## 70 Anderson Street - Preliminary Traffic Comments

Wed, Jul 20, 2016 at 2:28 PM

L1.0

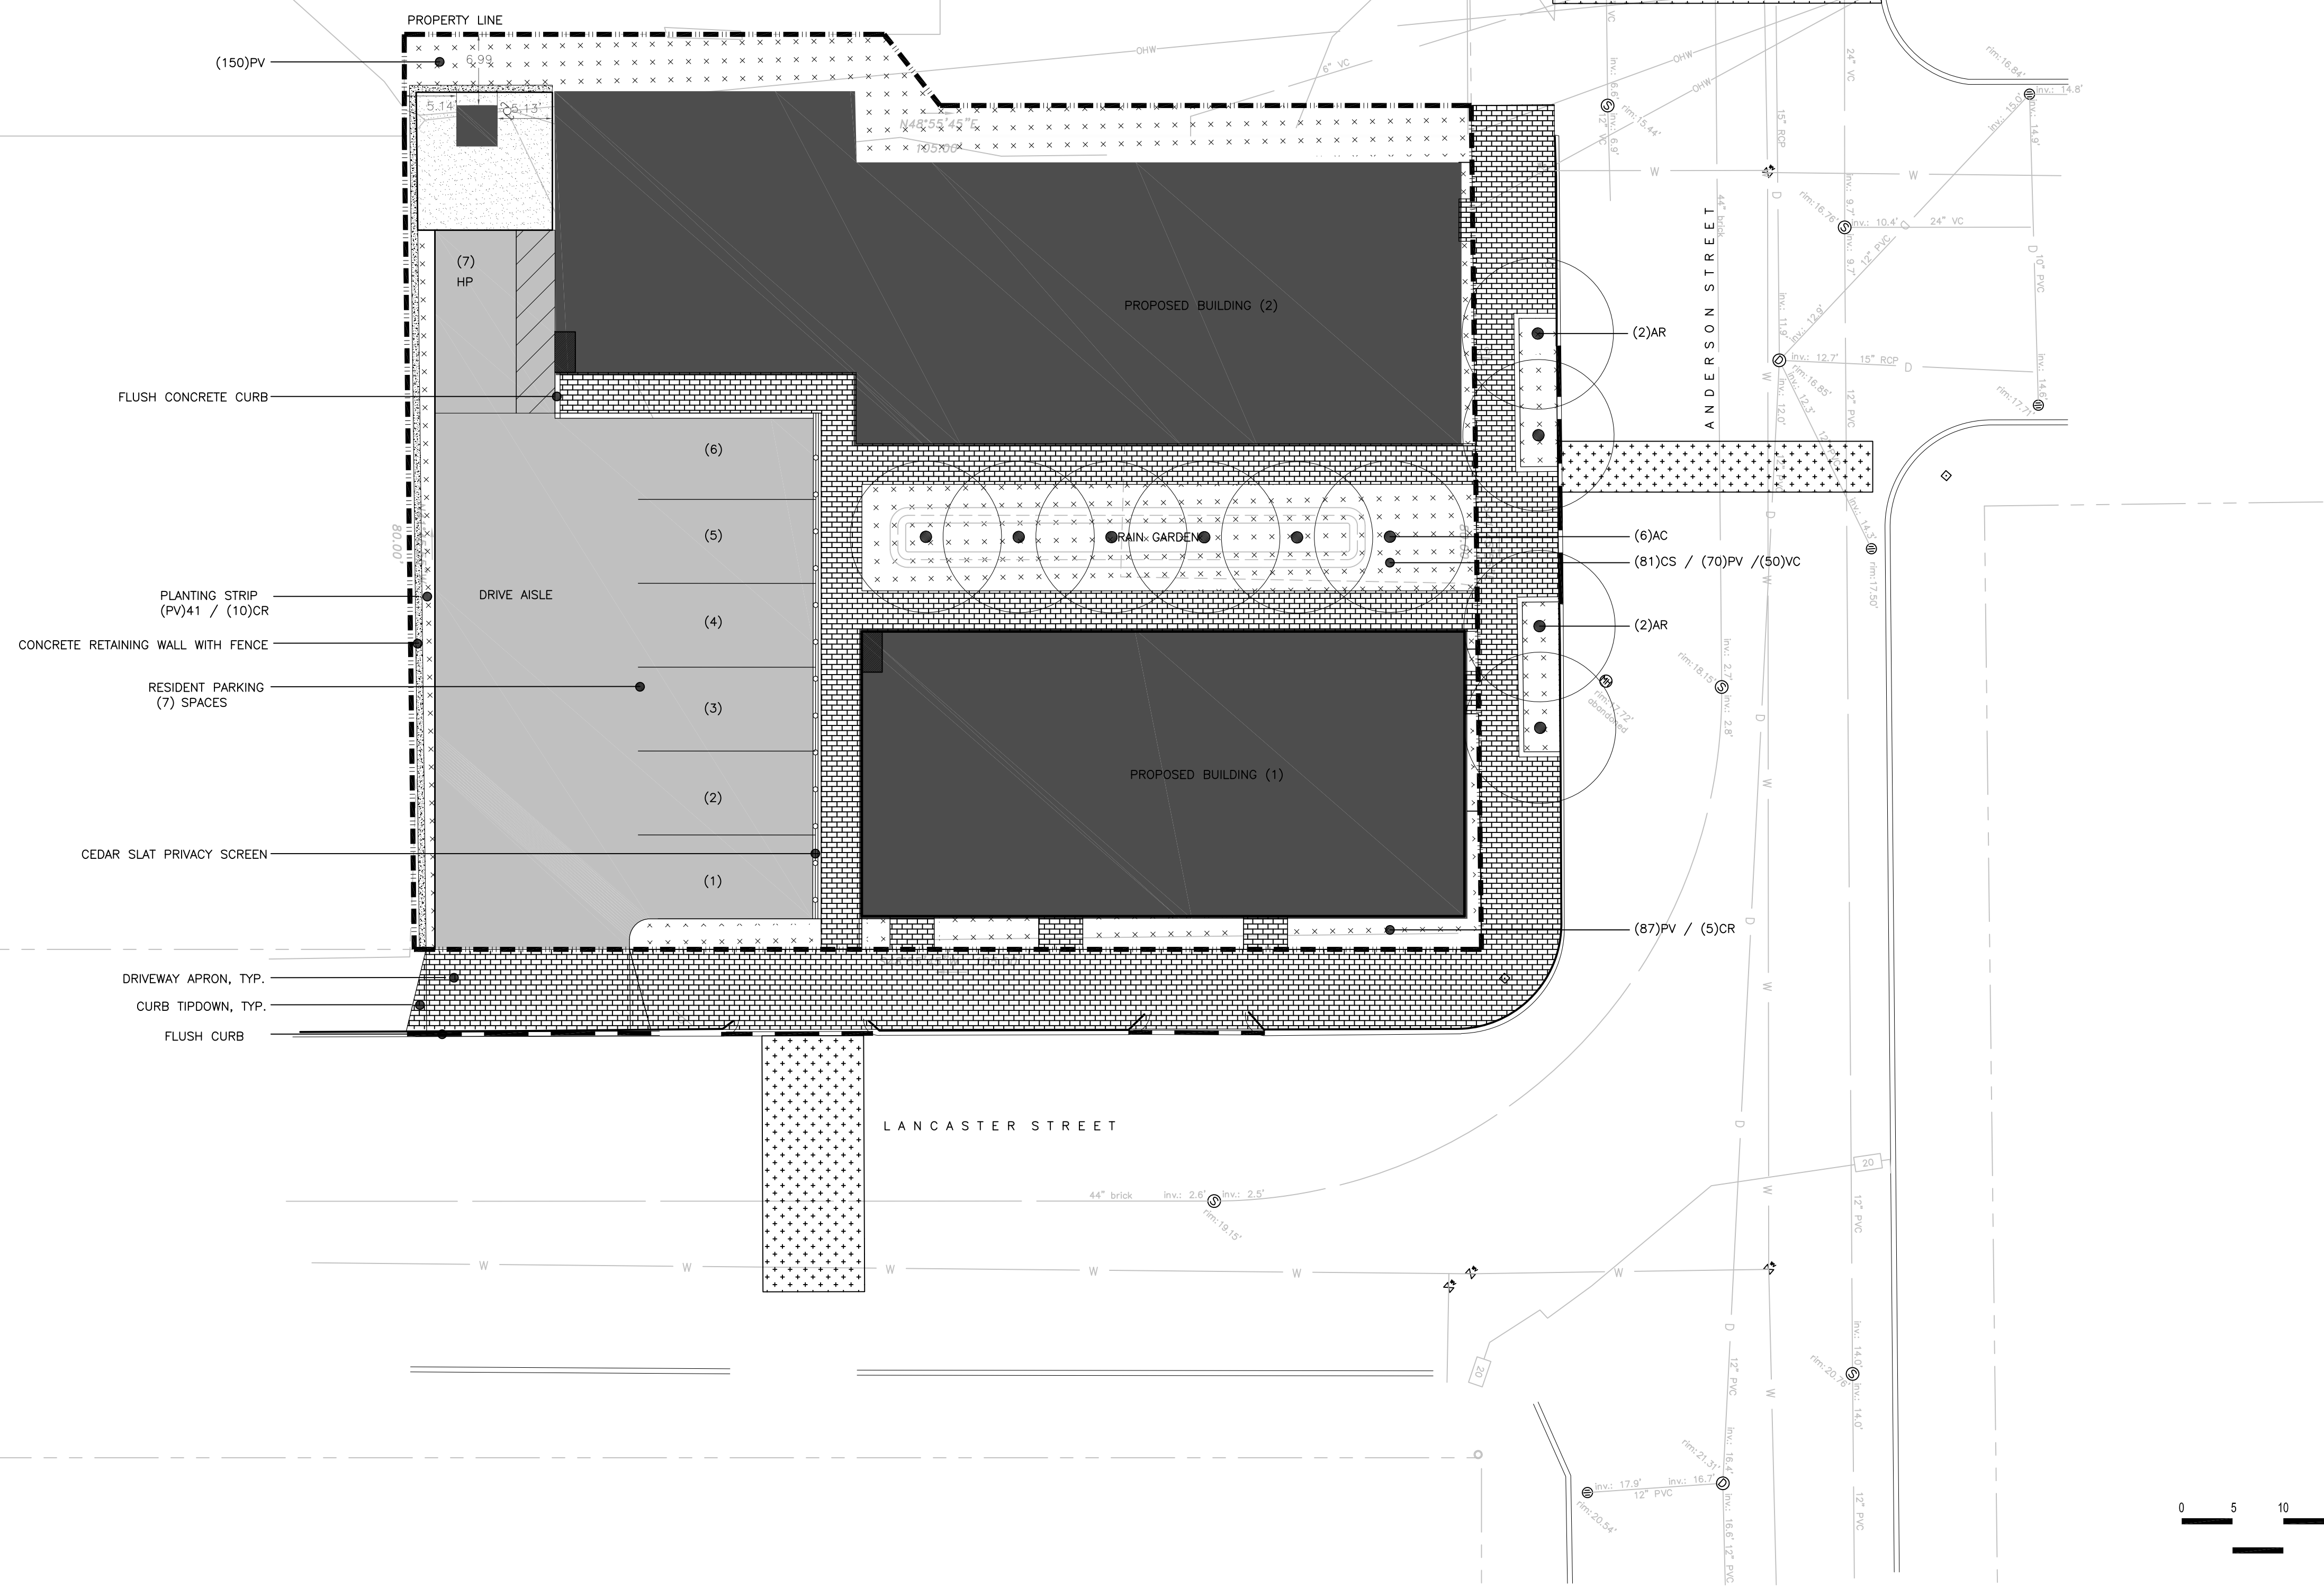
- The applicant is proposing parking spaces (one space meets City standards) that are slightly narrower than City standards (8.25 feet vs. 9 feet). An Auto-turn analysis should be provided documenting adequate vehicle circulation.

- The parking layout will likely require vehicles to back out into East Lancaster Street. Given low traffic volumes on East Lancaster Street and low trip generation from the site, I find this condition to be acceptable.

- The applicant is proposing a parking aisle width of 20 feet and this does not meet the City standards. An Auto-turn analysis should be provided documenting adequate vehicle circulation.

- The driveway apron along the sidewalk shall have a maximum cross slope of 2%. The plans shall include details specifying this requirement.
- A crosswalk on Anderson Street (to Madison Street) may be a requirement for this project. I am coordinating this item with other City staff and will provide feedback in the future.

- I continue to review and coordinate the design of the proposed sidewalk ramp on the project corner. I am coordinating with other City staff on the ramp design. Additionally, the crosswalk on East Lancaster Street shall include a fully compliant ramp on the south corner of the intersection.
